Land adj. Tern Inn, 1 Heron Way, Chipping Sodbury BS37 6XW

I write in respect of the above site, which benefits from extant planning permission from November 2022 for the erection of a convenience store with 9 no. flats above, with associated access and parking (LPA Ref: P/21/06188/F).

Following discussions with the convenience store operator, local residents and Dodington Parish Council the applicant wishes to make several minor amendments to the approved plans and documents. Accordingly, the applicant hereby applies for a minor material amendment by virtue of the provisions set out under Section 73 of the TCPA 1990.

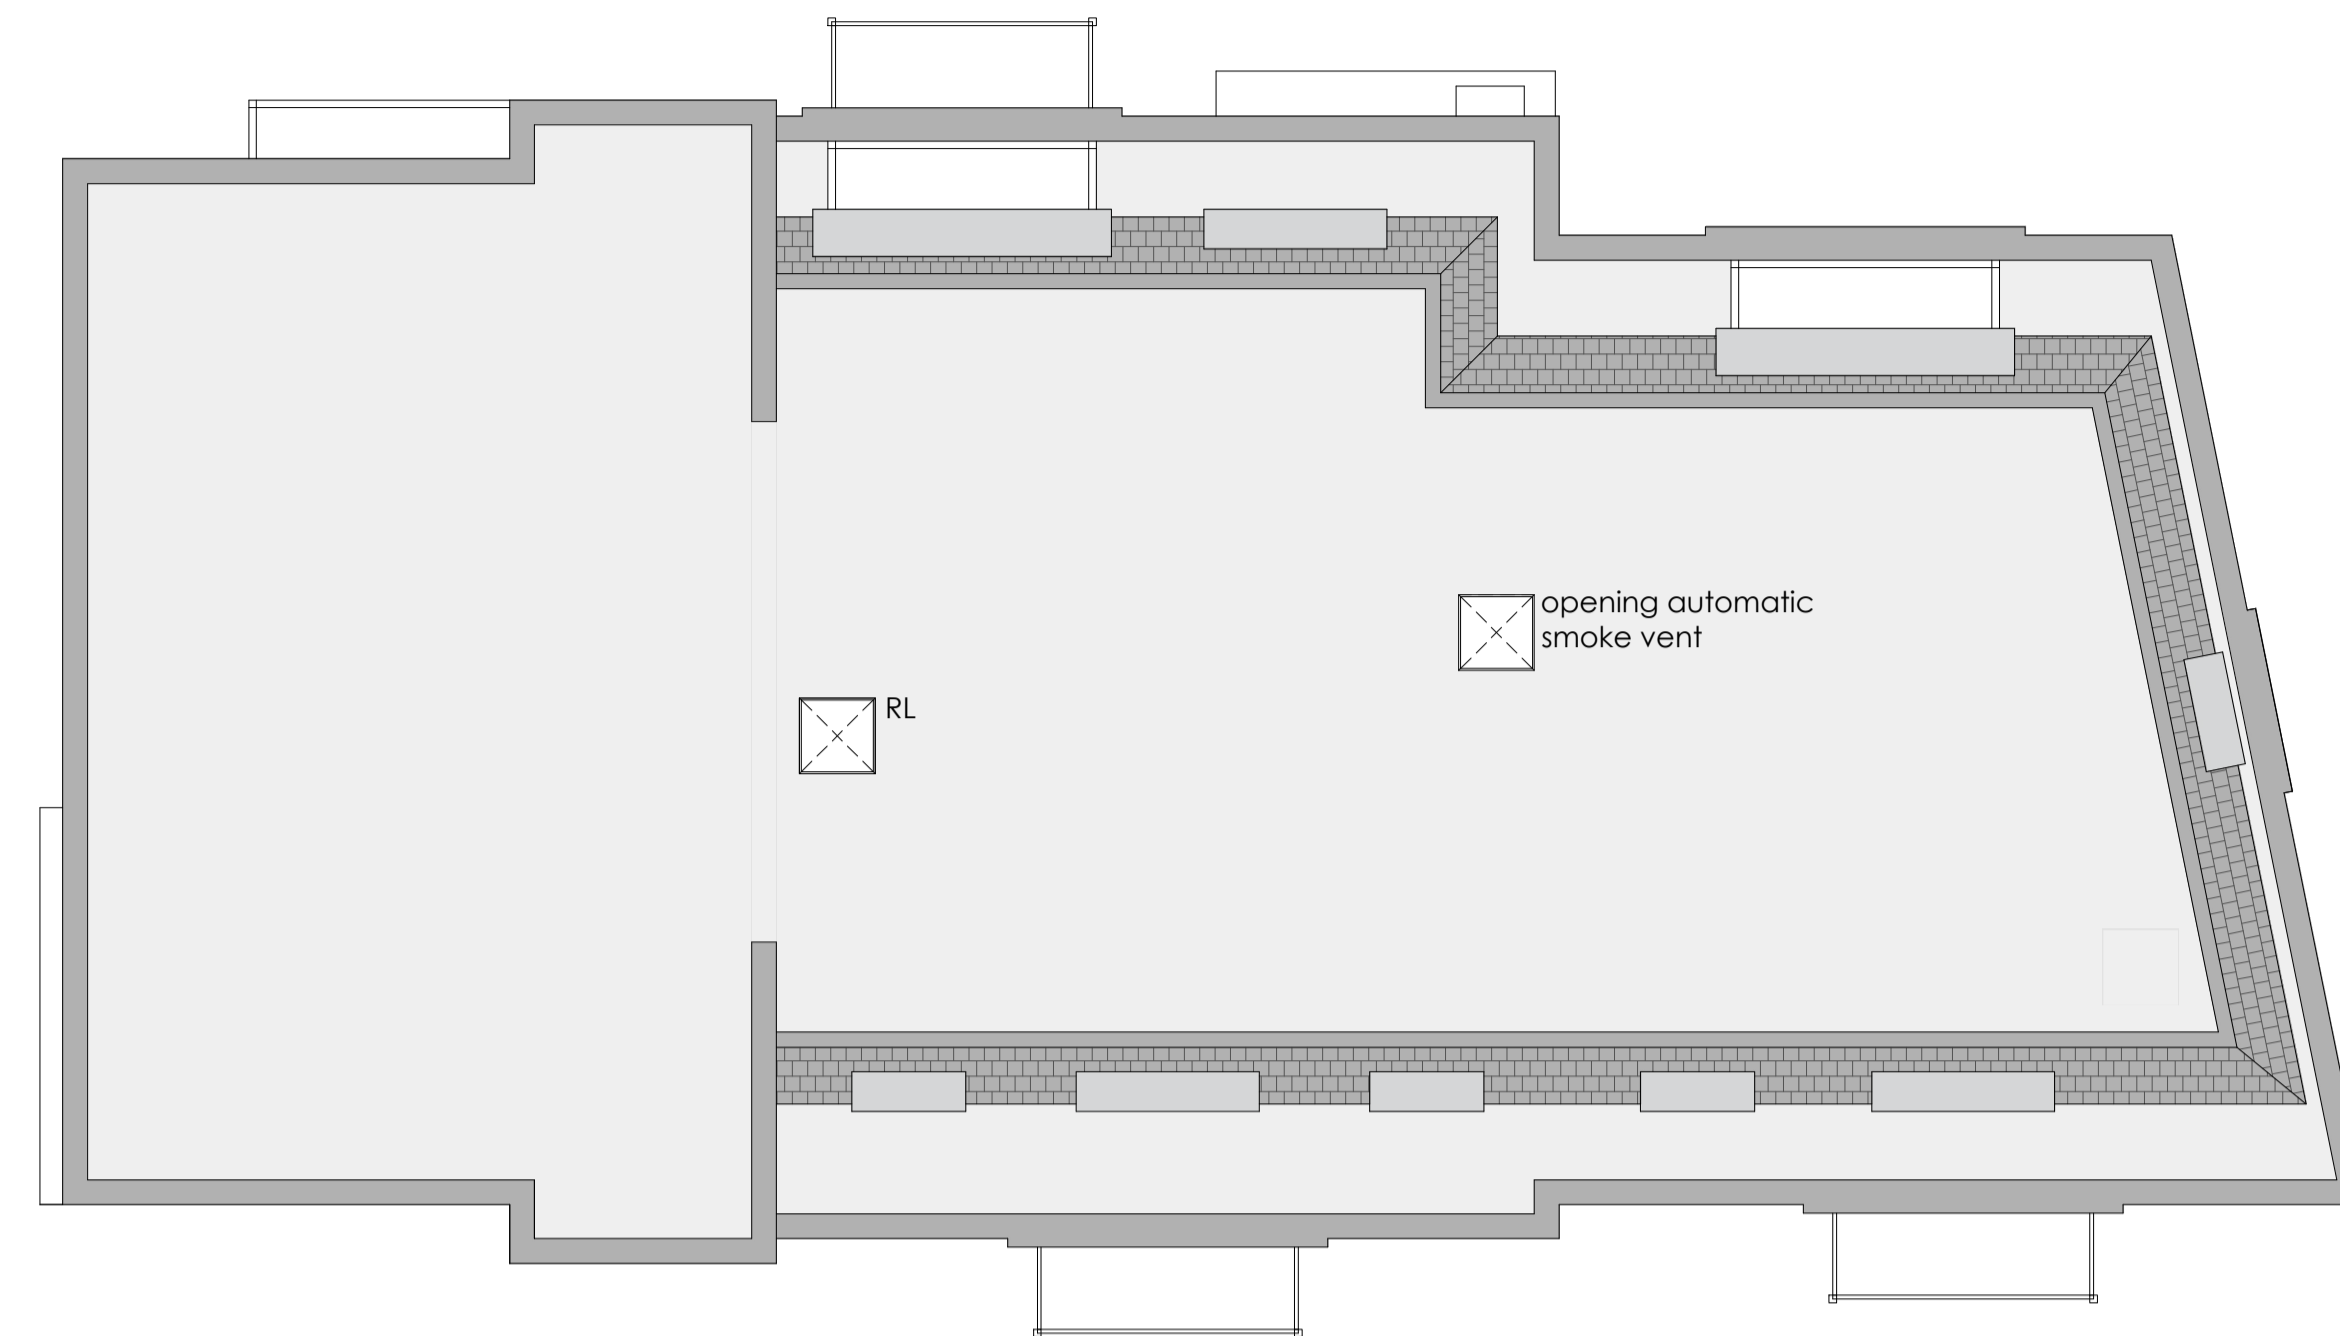
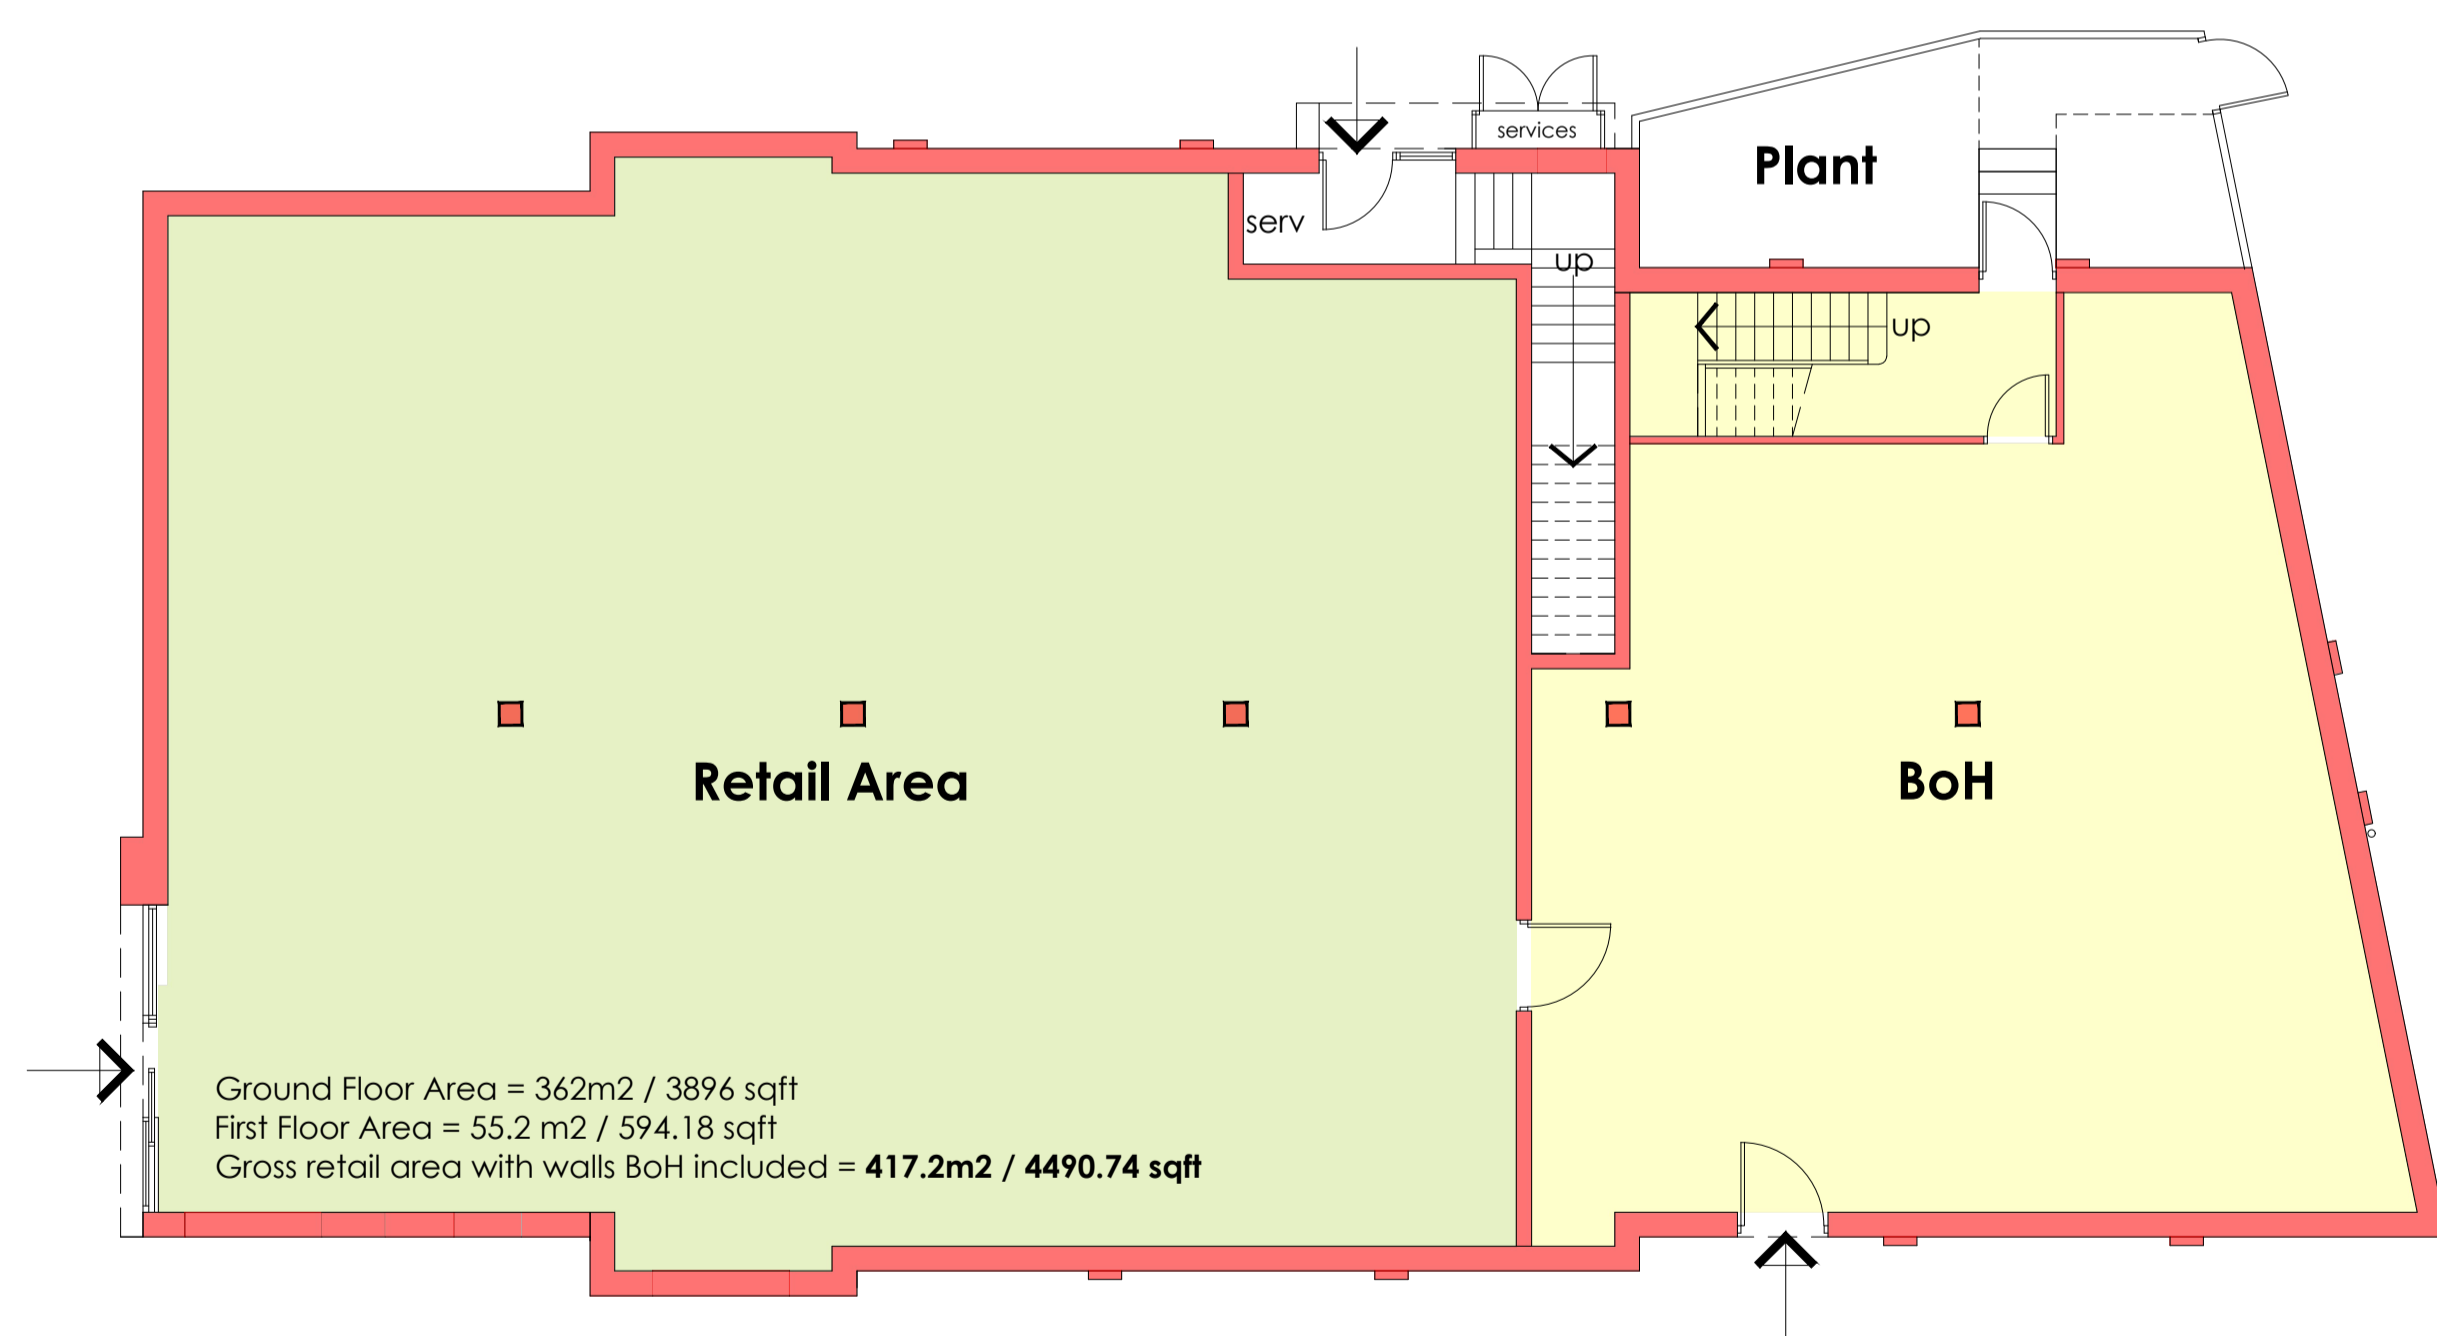
- 2. ATM** – The approved plans show an external ATM machine facing the parking area with bollards in front of it to prevent ram-raiding. The asset layout for the convenience store operator has now been finalised and they will be installing the ATM machine internally. Therefore, the planning drawings have been updated to reflect this change with the bollards now repositioned in front of the store entrance. As the external ATM has been omitted from the scheme, gas protection measures are no longer required, which means condition no 16 can be removed.
- 3. Residential windows** – The colour of the window frames for residential areas will change to RAL 7016 Anthracite.

6. **Ground Floor Commercial Windows** – The ground floor windows to the convenience store are to be removed at the request of the convenience store operator. The position of the approved windows acts to limit the placement of shelving, fridges and freezers, which would reduce the product offering of the store. To add articulation to the ground floor of building, tax windows are proposed for the former openings.
